8/1/2024

**SUBJECT: SFD2401-0039**  
**SINGLE FAMILY DWELLING**

Here are the results of all Inspections located at **1141 CAMERON HILL RD:**

REPAIR:
BREAK IN TOP CHORD LOCATED AT MIDPOINT

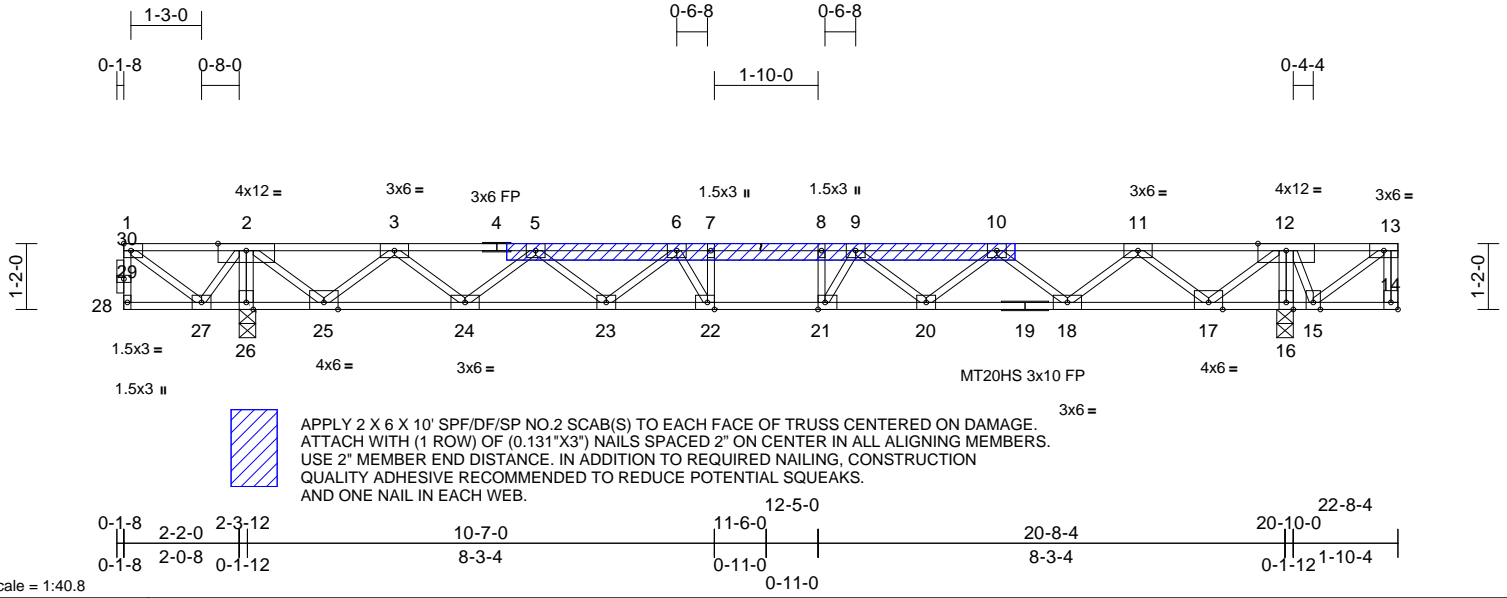
Porch post not installed at time of inspection  
Nail 2 ply lvl beam over garage door every 12"  
Missing air barrier under knee wall in garage and seal cracks  
Seal air barrier on house garage walls  
Missing anchor bolt to right of door in garage  
Nail both 2 ply trusses in garage per truss docs  
Anchor all interior load bearing walls per code  
Missing stud on end wall in pantry  
Missing correct ail guard on water line at top plate in pantry  
Jack stud on left side of window in kitchen not bearing  
Missing receptacle for kitchen island  
Missing Insulation baffles  
Missing nails in hurricane straps at kitchen window  
Replace notched stud at bottom plate to right a fireplace  
Fire caulk top of fireplace chase  
Missing 2x6 nailed in floor trusses in living room  
Need repair letter for floor truss repair in living room  
Stop inspection in living room at fireplace

Seal barriers between house ceiling and garage. Jack stud not bearing left of kitchen window. Need letter for truss repair. Missing sheet rock nailer for tub surround. Missing nail plate for drain in bath. Missing insulation baffles. Insulate P-trap for washer. Seal air barrier in bonus room. Missing wall stud by upstairs shower. Missing bracing on trusses. Support horizontal PVC every 4 feet. Cannot use t-ply for fire blocking in chases. Missing header above doorway under stairs.
